Michael File
Director
Strategic Assessments
Department of Planning
GPO Box 39
SYDNEY NSW 2000

I refer to the request referred to the Department of Planning on the 19th October, 2010 relating to the relocation of the proposed 500m range at the site of the regional shooting facility at Hill Top.

Client: **COMMUNITIES NSW**  
Project: **HILL TOP RANGE CLEARING SETOUT PLAN**  
Sheet: **SHEET 1**  
Drawing No: **21-17850-C004**

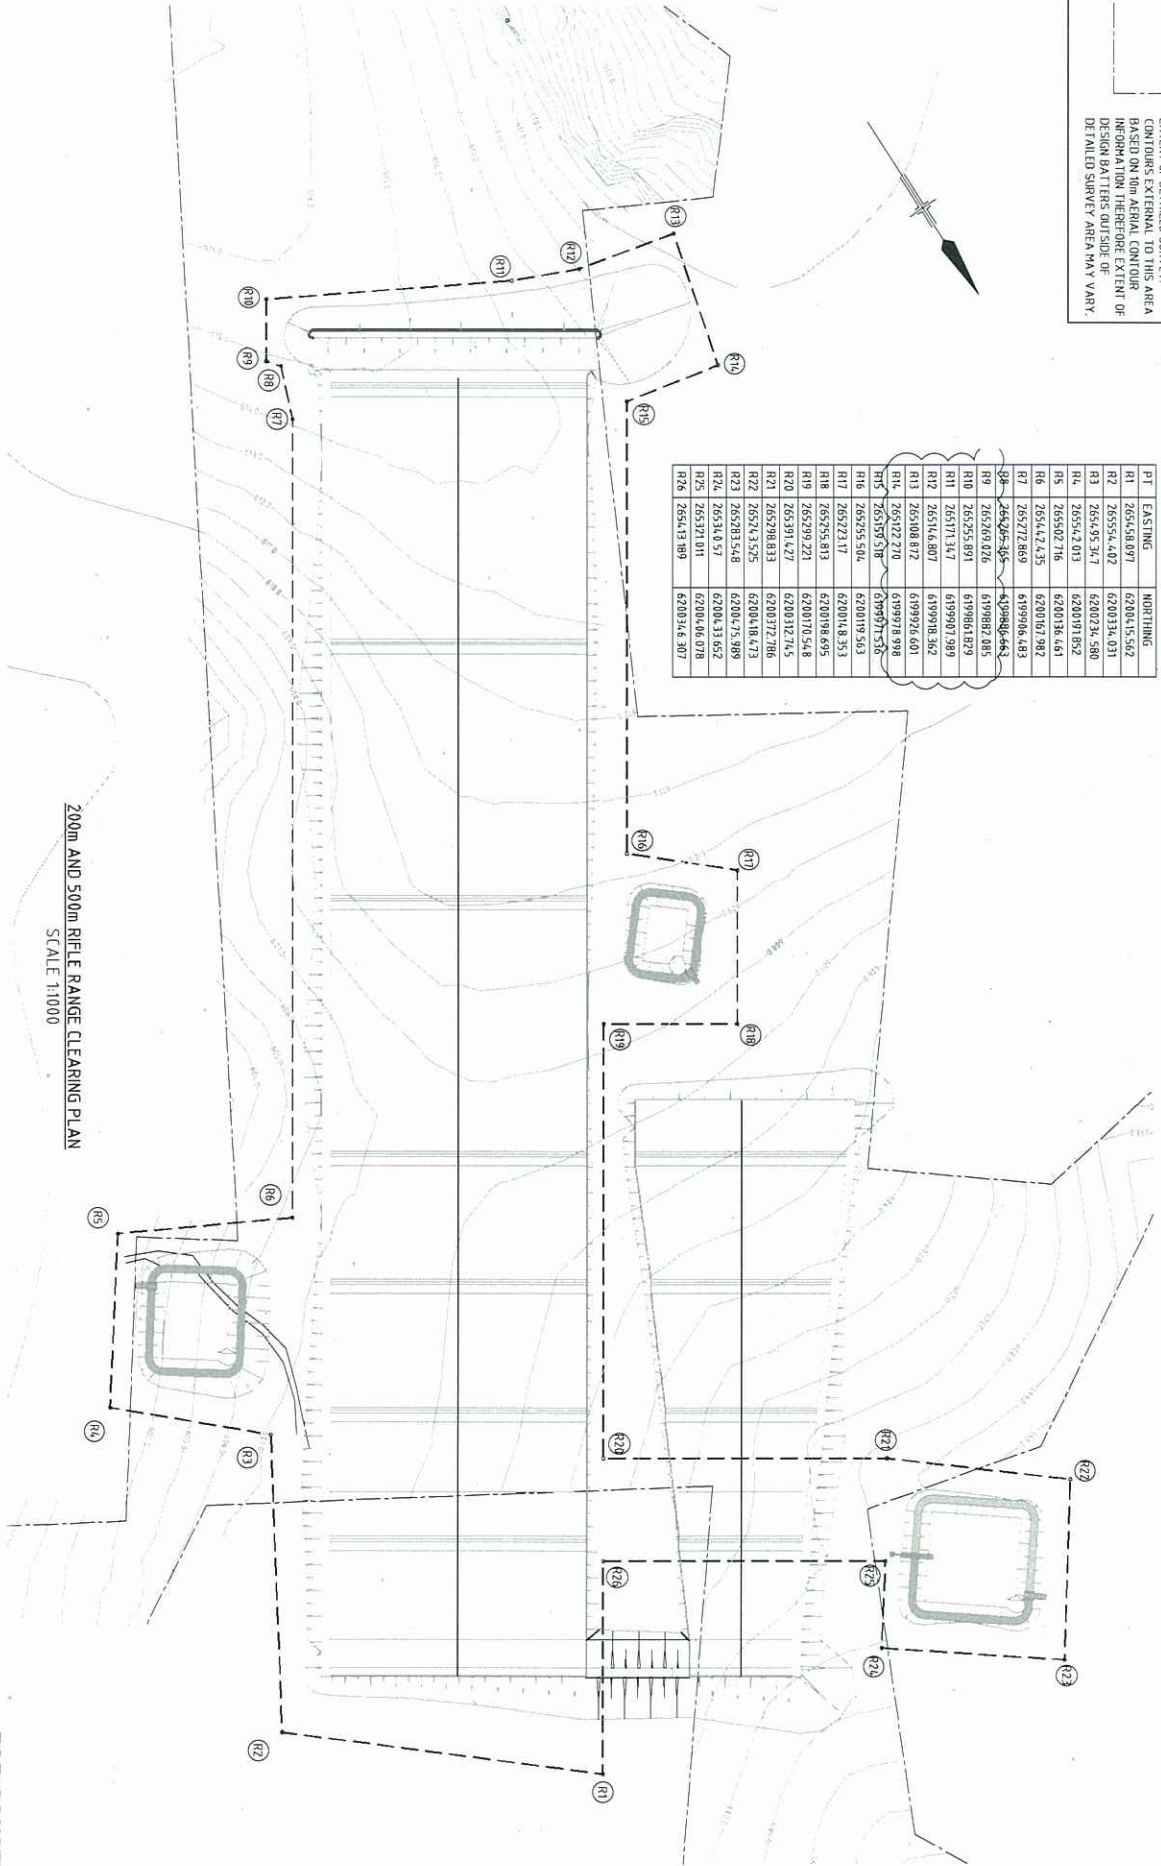
Our letter yesterday detailed that this agency varied the relevant drawing in a manner that would permit the range to be physically constructed, in summary, by moving the two ranges (500m rifle range initially) towards Wattle Ridge Road.

You indicated this morning that the Department would require additional information to allow it to vary the approved drawing in respect to the 500m rifle range, 200 pistol/rifle range and the sedimentation pond to the west of those ranges. In summary, you sought greater detail on the rationale for the relocation, any impact on the surrounding ecology, a clear delineation of the extent of the relocation and detail on the clearing work to date.

- (a) A summary by Alex Horton, Civil Engineer, GHD dated 20th October, 2010 of the rationale and clear ecological benefits for the relocation;
- (b) Drawing 21-17850-C004 which shows the earlier approved drawing (in red outline) and the relocated position (in black outline);
- (c) Drawing 21-17850-C010 which details the revised 200m and 500 range plan (in relocated position) and dated 11th October, 2010.
- (d) A report and drawing by Peter Cornish, Hard & Forrester (Registered Surveyor) of the clearing work undertaken to date
- (e) Related to (c), a drawing (21-17850-SK100) showing the clearing path/area to date;
- (f) A revised overview of the positioning of the various range danger templates which continue to be contained within Lot 100, DP 1088254.
